**A/193/21/L**

*Dormouse Cottage, The Square, Angmering, BN16 4EA*

*Listed building consent to remove existing stud wall in breakfast room and return wall to its original position to with a new stud wall to form a new shower room (including toilet and basin).*

NB: DETAILED MEASUREMENTS FOR PROPOSED SHOWER ROOM HAVE ALREADY BEEN SUBMITTED IN A SEPARATE DOCUMENT

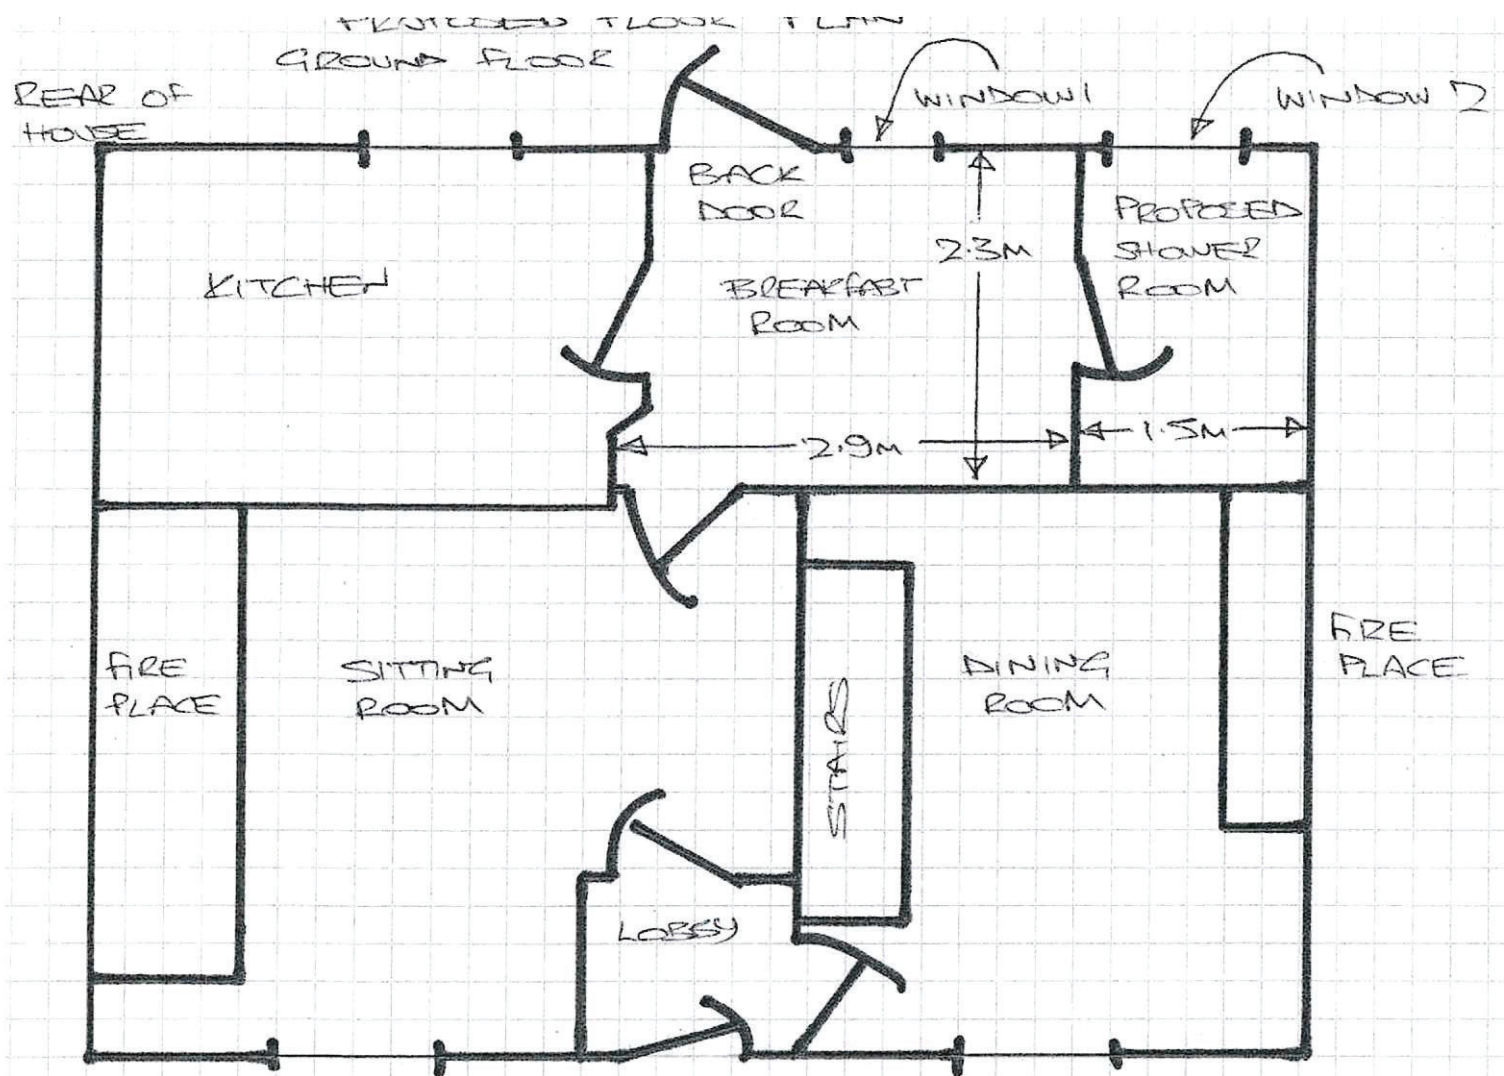
The proposal is to remove an existing stud wall in the breakfast room and build a new wall in what is considered to be its original position. This will create a new shower room (including toilet and basin). A comprehensive heritage statement has been provided by the applicants which helps to identify that the existing wall is of modern fabric. It is also clear that there was a wall in the proposed location. I am of the opinion that the relocation of the wall would not cause harm and that it would enable the better use of this part of the building.

I note that there are references to a new window to serve the proposed shower room, but it is not clear if this would form part of the application. If it is, I would like to understand what the window would look like and think that this could be dealt with by a suitably worded condition if you are minded to approve the application.
